**KIRKLEES METROPOLITAN COUNCIL
INVESTMENT & REGENERATION SERVICE**

**DELEGATED DECISION TO DETERMINE APPLICATIONS FOR
CONSENT, AGREEMENT OR APPROVAL REQUIRED BY CONDITION**

Reference No:	2024/44/90237/W
Site Address:	adjacent, Britannia Road, Golcar, Huddersfield, HD3 4QB
Description:	Discharge of conditions 3 (construction environmental management plan), 4 (public right of way), 5 (retaining walls), 6 (Phase II Report), 7 (Remediation Strategy), 9 (Remediation Validation Report) and 18 (Japanese Knotweed) of previous permission 2021/92062 for erection of 9 dwellings and associated works
Recommending Officer:	Nick Hirst

Application: 2024/90237

PROPOSED CONSTRUCTION SITE PLAN SCALE 1:125 @ A1

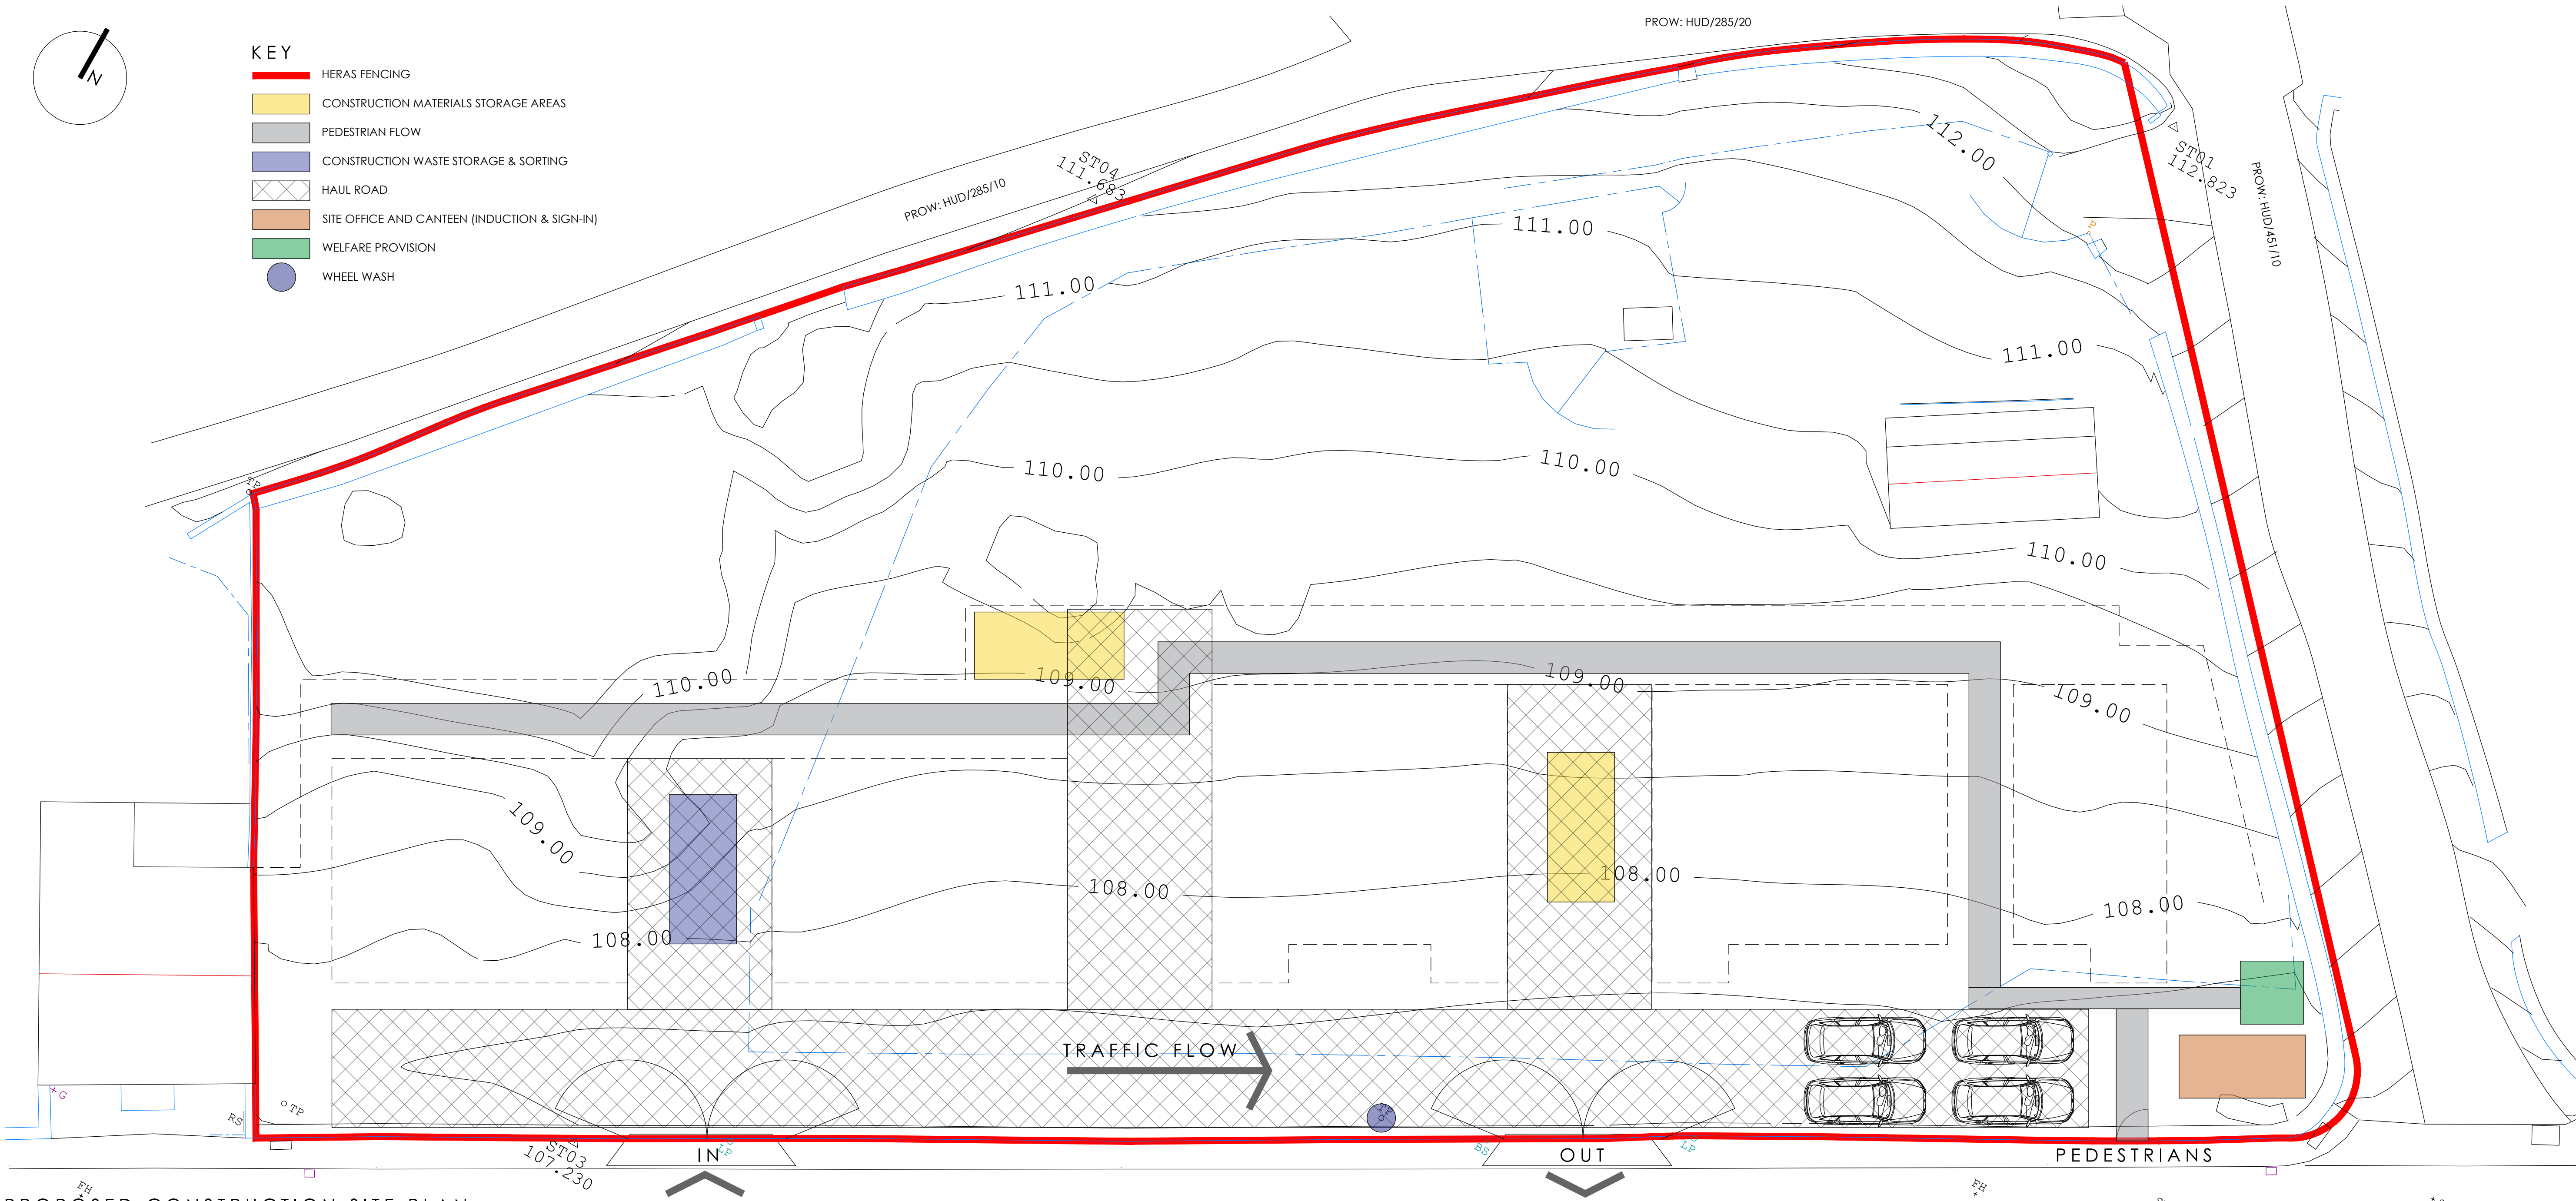
The applicant has provided a detailed photographic survey of the PROWs around the site which establishes the current state of repair. This will allow an evidenced assessment of if / when any damaged is caused during the construction period. The applicant has also confirmed that no HGV vehicles will utilise the routes, with all access to the site to be via Britannia Road. Heras fencing will be erected around the site, separating it from the PROW.

The above measures have been discussed with K.C. PROW, who raised no objection. Officers are satisfied that the measures are sufficient to ensure that the PROW will remain open and unprejudiced during construction. Therefore, it is recommended that the details be approved. An ongoing requirement prevents full discharge at this time, and a note regarding this is recommended to be included on the decision notice.
